Our Ref: EN010163

Date: 11 June 2025

### Application by Renewable Energy Solutions (RES) for an order granting development consent for the Steeple Renewables Project

#### Advice following issue of decision to accept the application for examination

Drawing file: published-documents / EN010163-000051-Doc 2.35 Cable Crossing Plan.pdf

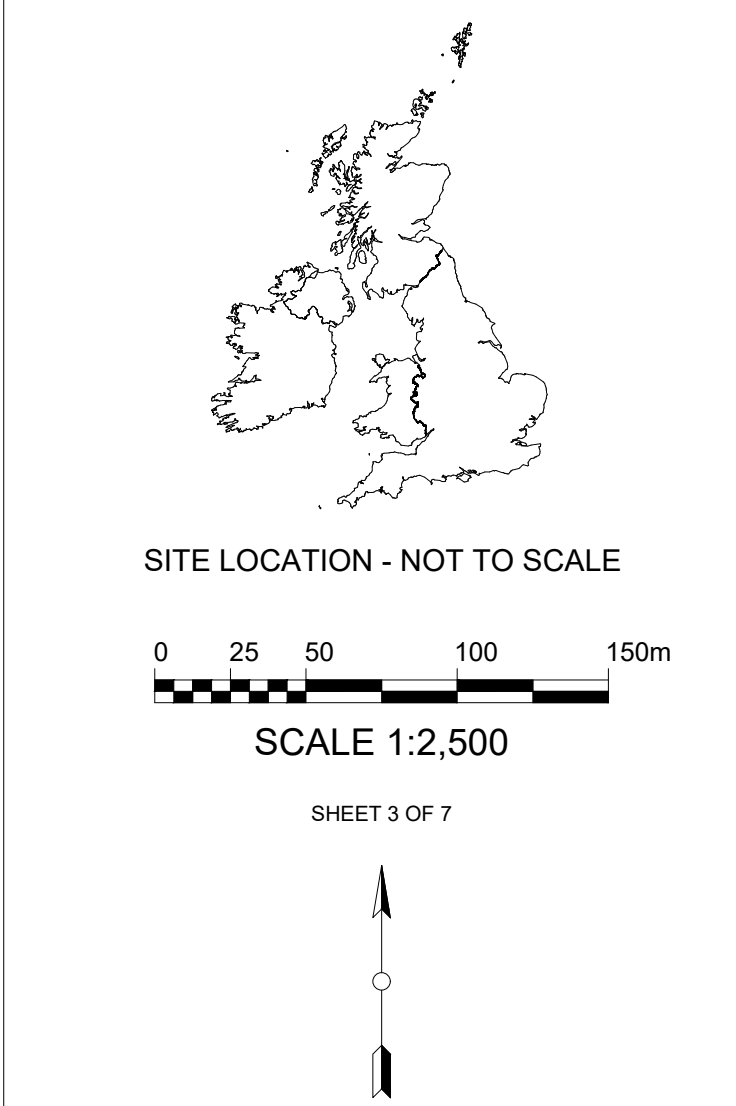
The plan has no cut lines, including plans that have been overlapped on certain pages. The applicant is advised to amend this.

Drawing file: published-documents / EN010163-000057-Figure 6.5a - Visual Receptors (Settlements, A Roads, B Roads and Long Distance Routes).pdf

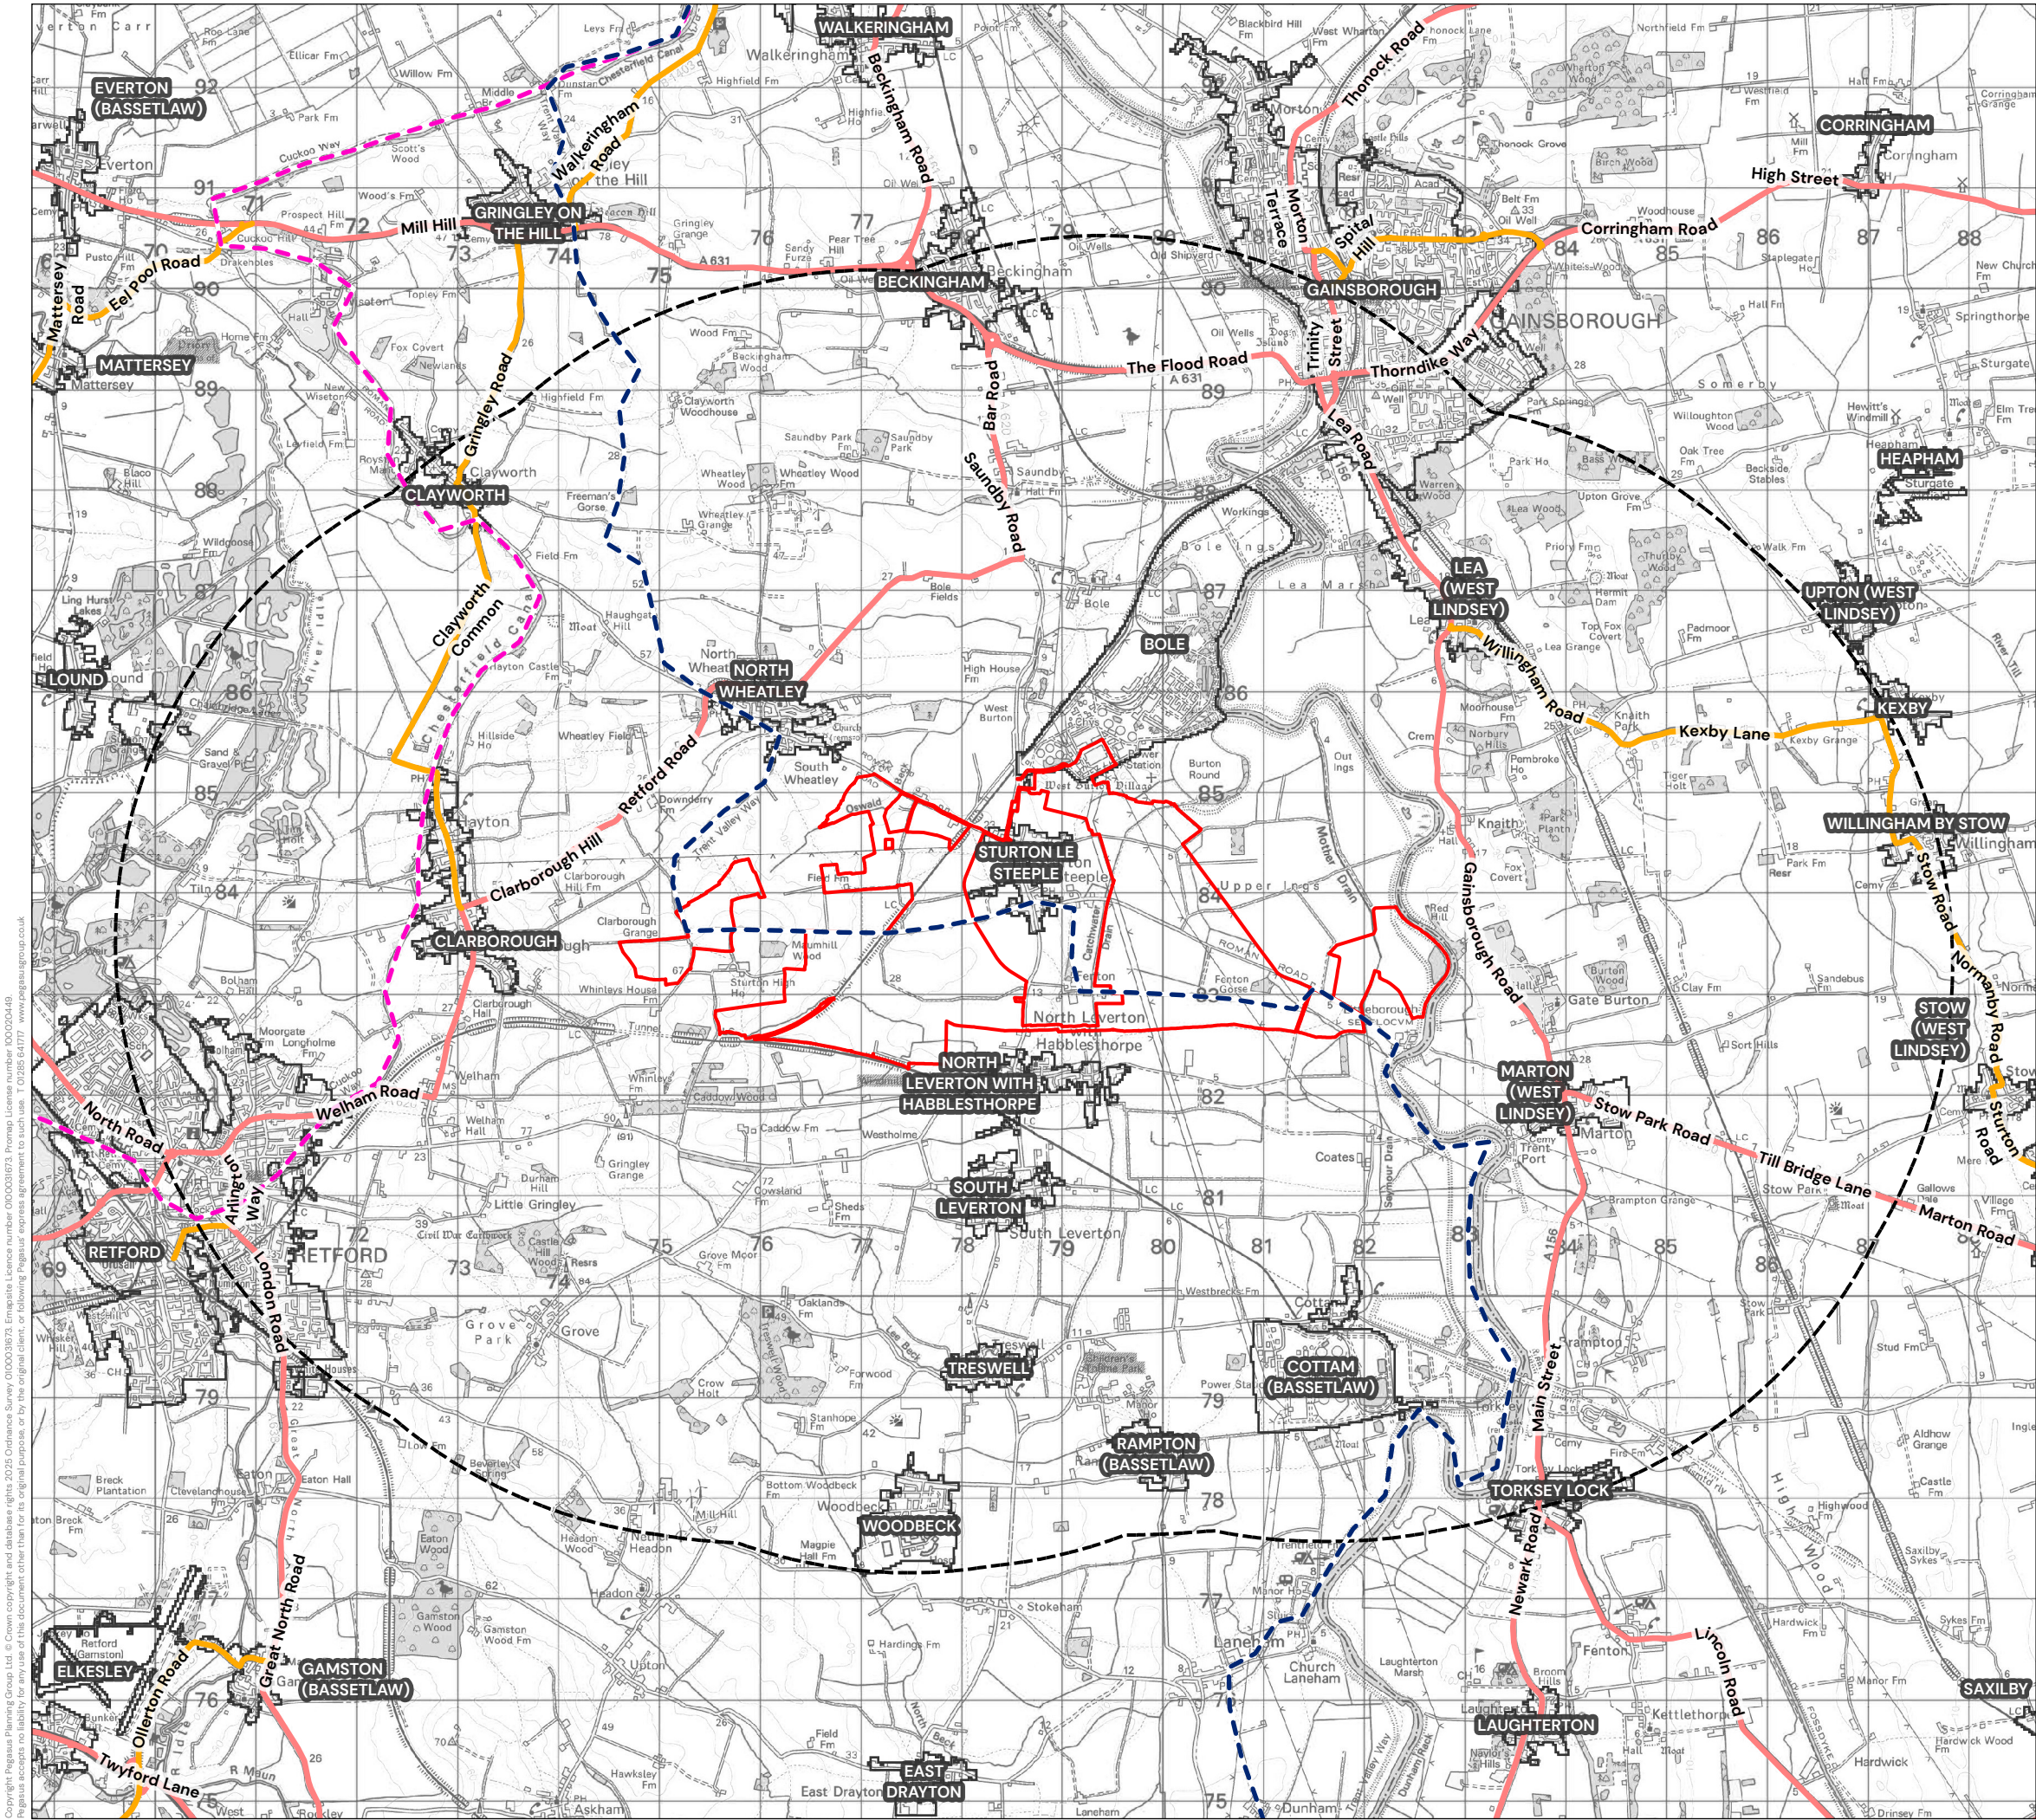
The document received opens as '6.4.6 Figure 6.5c Visual Receptors (Settlements, A Roads, B Roads and Minor Roads)'. It is requested that the Planning Inspectorate receive the correct version of Figure 6.5a (Doc 6.4.6) before the Relevant Representation period begins.
